September 6, 2016

Re: 23 Ocean Mixed Use

Response to Planning Staff Review and Planning Board Workshop

## Siding Examples

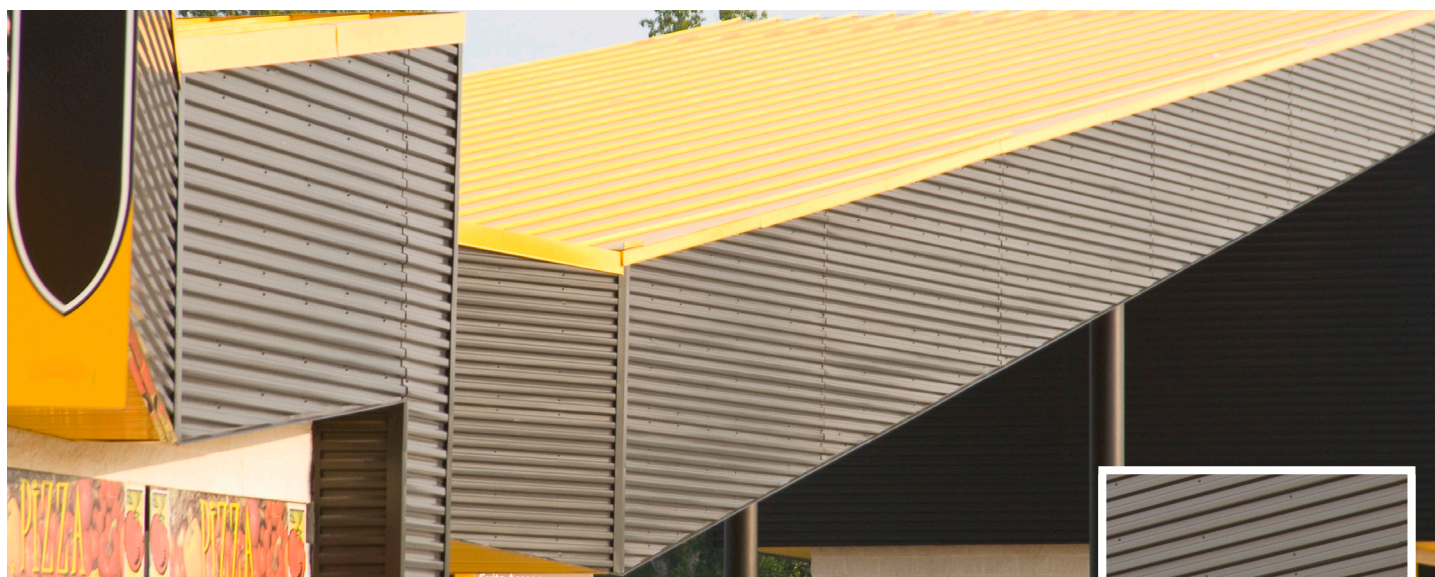
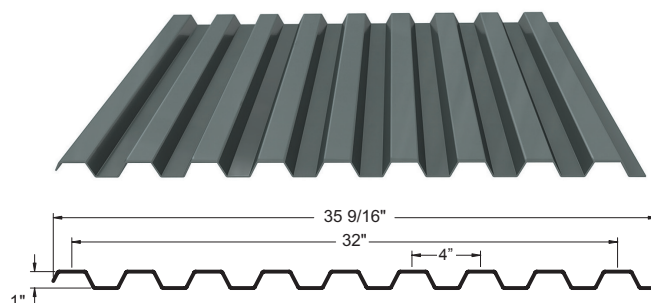
4. Standard (1) g. Building Materials – “*Metal siding is not found in either the residential or commercial context. Revise the material selection – fiber cement clapboard is recommended.*”

- a) Our intention to use horizontal metal siding that mimics the texture and shadow qualities of clapboard but does not carry the maintenance burden of painted clapboards. Example images were presented at the Workshop that illustrate real world instances of this approach. Those images are attached to this submission. Our impression is this was viewed as acceptable by the Planning Board.

**A-2.2**

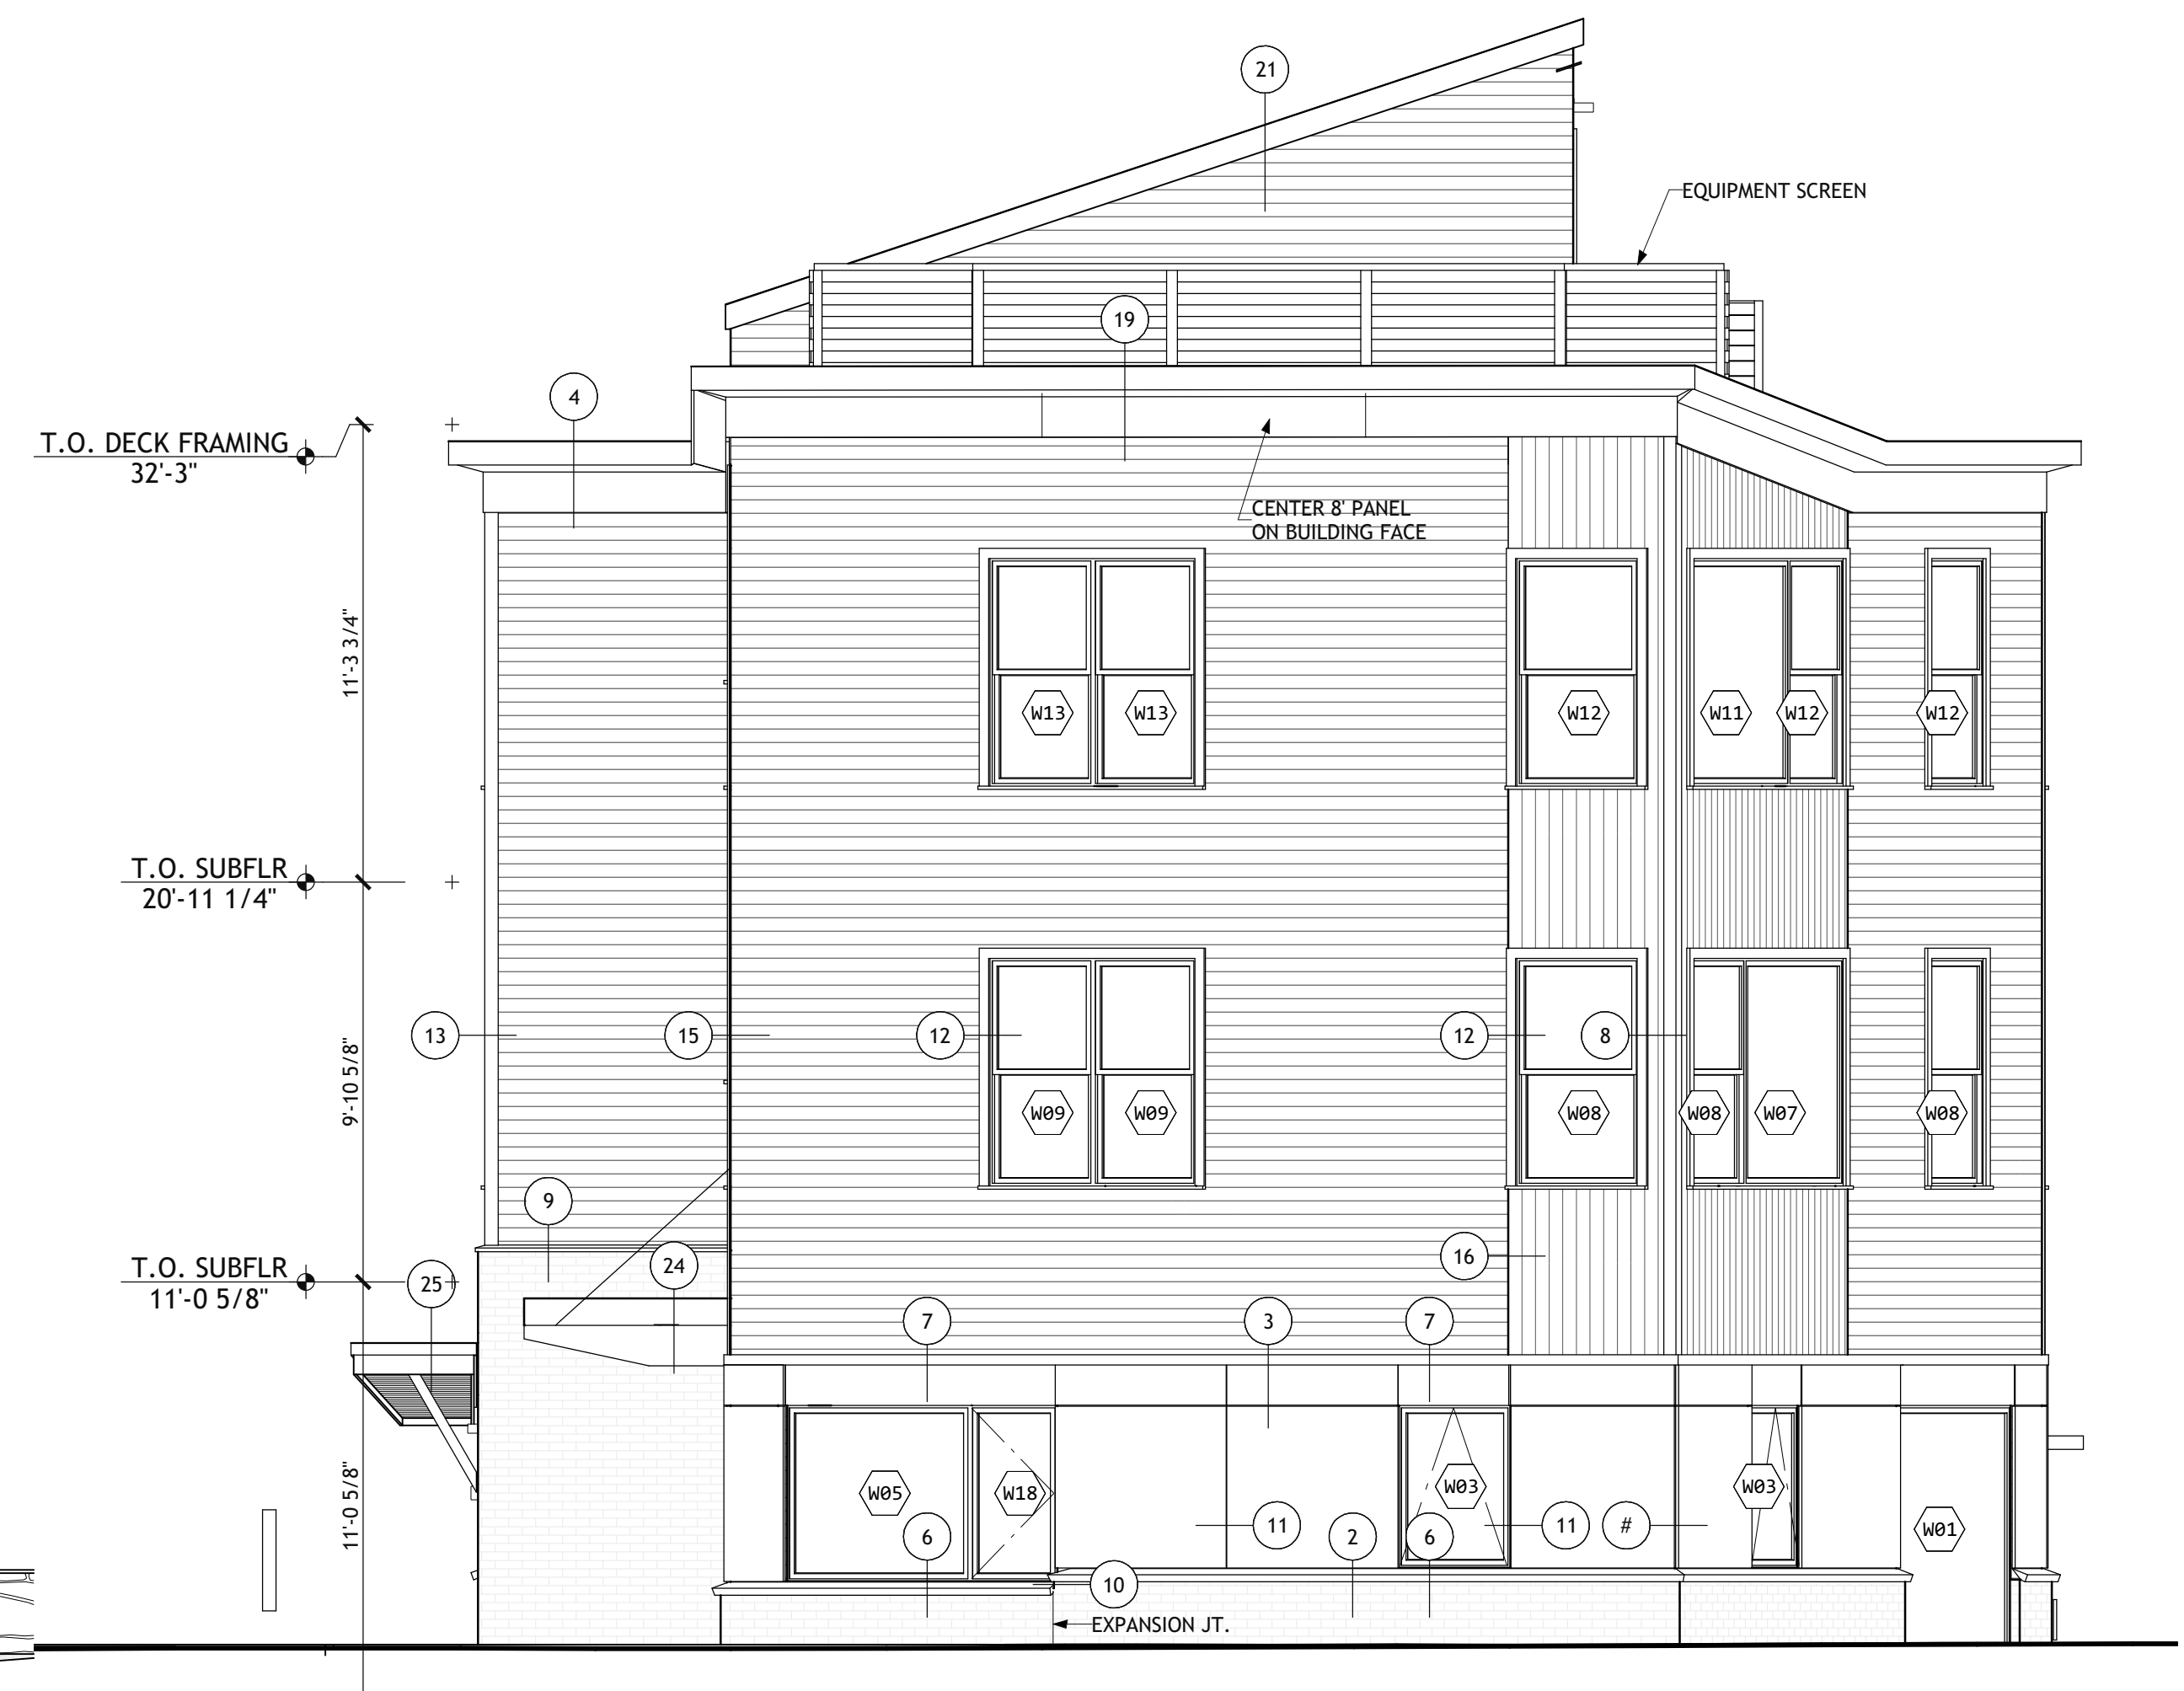
6. (XII.4.g) Request information on the location of HVAC equipment.
 - a) The external HVAC equipment will consist of six roof mounted condensers for mini-split heating and cooling system.
